DELEGATED HOUSEHOLDER DECISION

Item No.	Report of the Head of Development Management and Building Control	
Address:	4 ALBANY CLOSE ICKENHAM	
Development:	Erection of first floor extension and associated alterations to allow for part-conversion of roof space to habitable use	
LBH Ref Nos:	79843/APP/2025/3245	
Drawing Nos:	PP-14584665v1 MS29201 MS29203 MS29204 MS29205 MS29202 HS.01.26	
Date Plans received:	23-12-25	Date(s) of Amendments(s):
Date Application valid	22-01-26

1 **Block Plan**
1 : 500

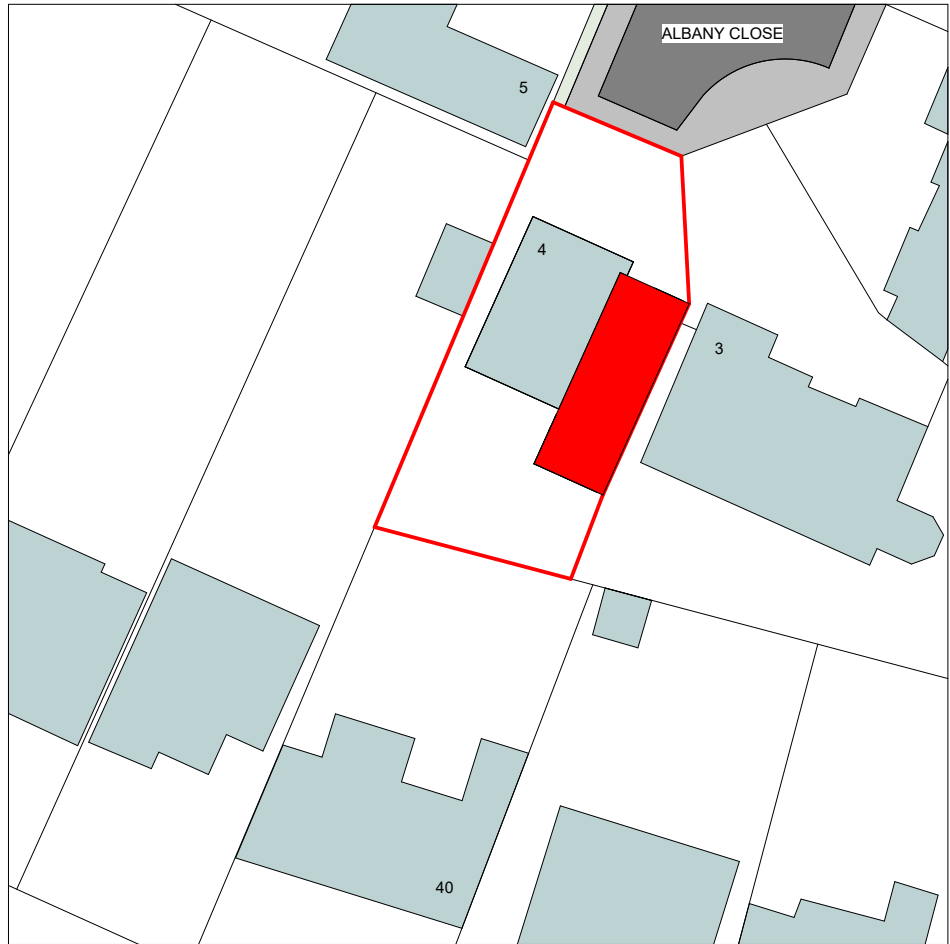
The rear first floor window would, ordinarily, introduce overlooking into the garden of no. 40 from the application property, whilst the rear-to-rear separation distance between the properties is approximately 19m, below the minimum limit specified within the Local Plan. As such, the overlooking introduced would be above the specified tolerable limits. In this instance, this level of overlooking would then be greatly exacerbated by the shallow depth of the garden of the application property. The distance from the rear of the first floor extension to the rear boundary of the application site is approximately 6m. To this extent, the view afforded by the proposed first floor rear bedroom window would effectively be directly onto the garden of no. 40, with no reasonable buffer in between. Such an opening would therefore significantly undermine the privacy of this neighbour and, appearing at the rear end of the garden, would be visually intrusive for this neighbour being directly visible from their rear-facing habitable rooms. This loss of privacy would be significantly over and above any (negligible) existing overlooking of the site.

- The garden of no. 38 Halford Road is much deeper than the application property. As such, the impacts on the privacy of the respective neighbour would be lessened. The garden of the application property is notably shallow (approx. 6m), meaning the proposed rear first floor window would effectively look directly onto the garden of no. 40 Halford Road, failing to appropriately preserve the amenity of this neighbour, whereas the principal outlook to the first floor window of no. 38 Halford Road would be to their own garden. It is noted that the back-to-back distance between no. 38 Halford Road and the respective neighbour no. 3 Albany Close is also approximately 21m, compliant with Local Policy.

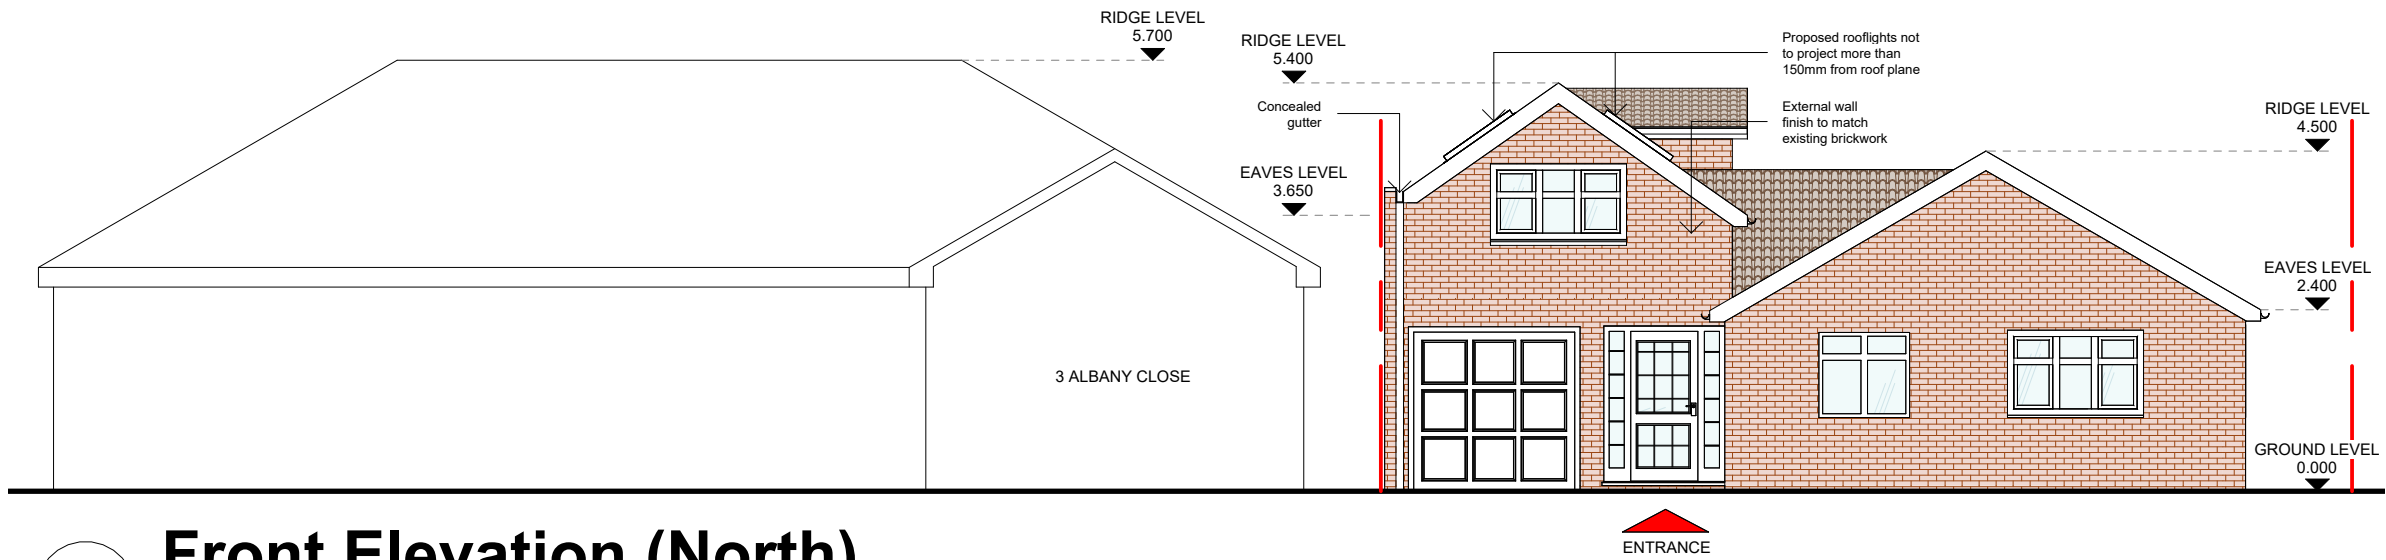
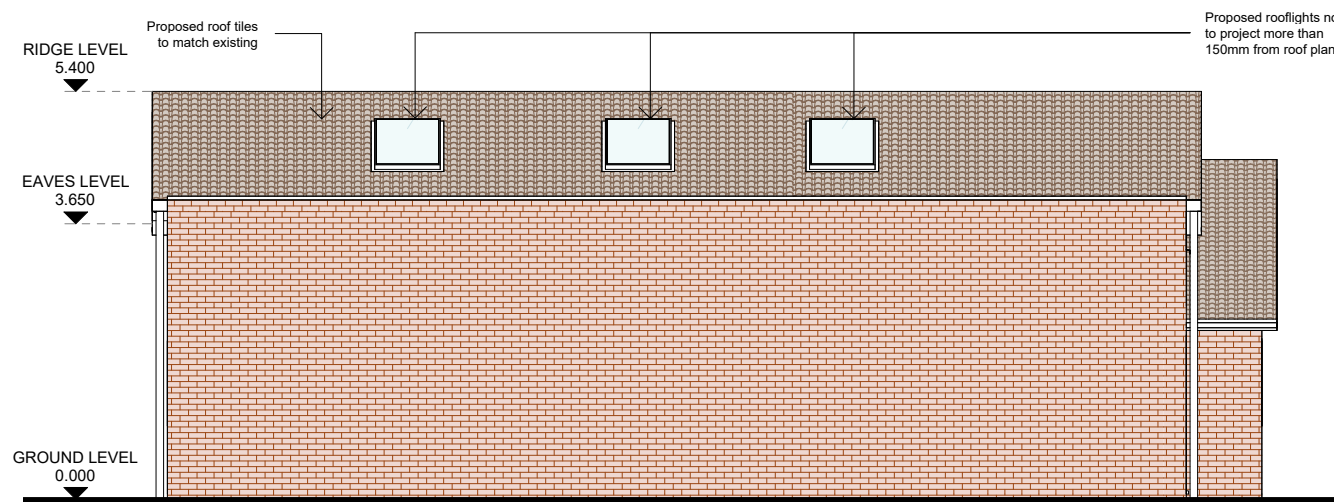
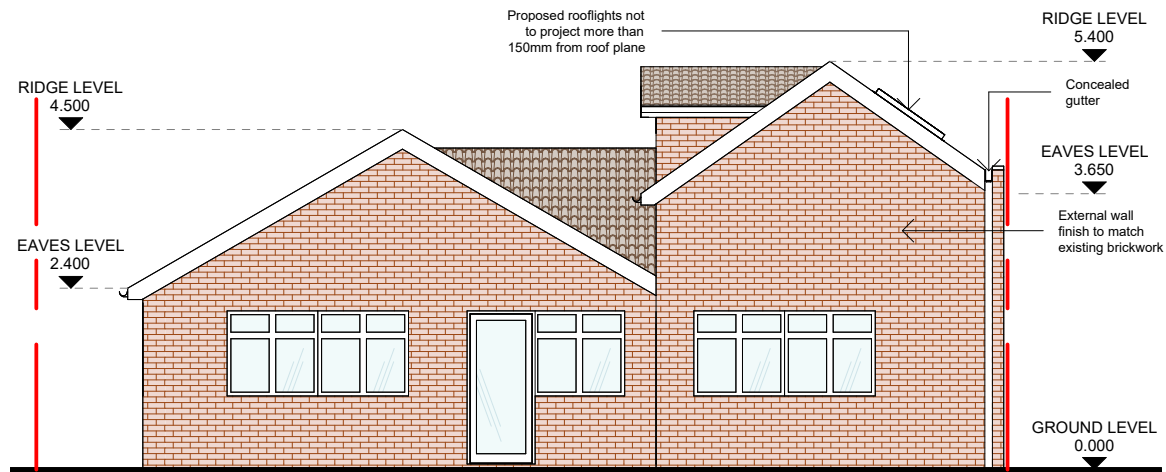
The application proposes the construction of a first floor extension to part of the existing dwelling, atop the existing garage and rear projection. The extension would have a ridge height of 5.4m, 0.9m above the ridge of the existing front gable, and be finished in a pitched roof with front and rear gables.

In this instance, it is considered that the first floor extension would not represent a sympathetic addition to the property. The ridge of the extension would notably exceed the ridge of the existing feature front gable, thereby failing to appear as subservient to the main dwelling. This lack of subservience in height would be conflicted by the much narrower gable width than the main front gable, which together undermines the visual coherence of the dwelling. This confliction, between being the tallest feature of the dwelling but attempting to retain the appearance as a secondary gable, would negatively impact upon the overall visual appearance of the existing property, with the first floor extension drawing attention away from the existing feature front gable due to its superior

This lack of visual coherence would be exacerbated with the design of the extension itself. In addition to being higher than surrounding properties, the eaves of the extension would be of differing heights, thereby appearing as unequal / unbalanced in proportions and asymmetrical - conflicting with the design of the existing property and surrounding bungalows. Furthermore, the large expanse of brickwork to the east-facing side elevation would appear as out of scale with the proportions of the existing dwelling, appearing as an unduly large and imposing feature which fails to appropriately integrate with or respect the generally modest proportions of the property.

Additionally, the unequal / unbalanced eaves of the extension, and large expanse of brickwork to the east-facing side elevation (which rises above the height of the eaves of the neighbouring dwelling) would also be uncharacteristic features which would further dilute the existing uniform character exhibited at the end of the Close, negatively impacting the existing appearance of the street scene.

Whilst not a side extension per se, Local Policy also generally requires two storey domestic extensions to be set in at least 1m from side boundaries, so as to retain sufficient openness in the street scene. The flank wall of the first floor extension would run flush with the side boundary of the site which, given the proximity of no. 3, would result in an overly cramped appearance, particularly given the current low roof height of the existing garage and rear extension.

Whilst it is indicated on the proposed plans for this window to be obscurely glazed, the plans do not indicate this window to be fixed shut, hence the issue of overlooking remains unresolved. Furthermore, given that the proposed window would be the sole window serving a habitable room (bedroom), it would also not be considered appropriate for such a window to be conditioned to be obscurely glazed and fixed shut, as this would not provide an acceptable internal living environment for the occupier of the habitable room, given the lack of an adequate outlook. To this extent, to impose such a condition would not be considered an acceptable compromise in this instance.

The proposed first floor rear opening, by virtue of its siting, height, openable nature and the limited separation distances involved, would result in the introduction of a harmful level of overlooking to the rear of the site, significantly impacting upon the privacy of an adjacent neighbour, namely no. 40 Halford Road. As such, the proposal would represent an un-neighbourly form of development which would not achieve a satisfactory relationship with adjacent dwellings, failing to preserve the amenity of a neighbouring property. The proposed development would therefore not conform to the requirements of Policies DMHB 11 and DMHD1 of the Hillingdon Local Plan: Part Two - Development Management Policies (2020).
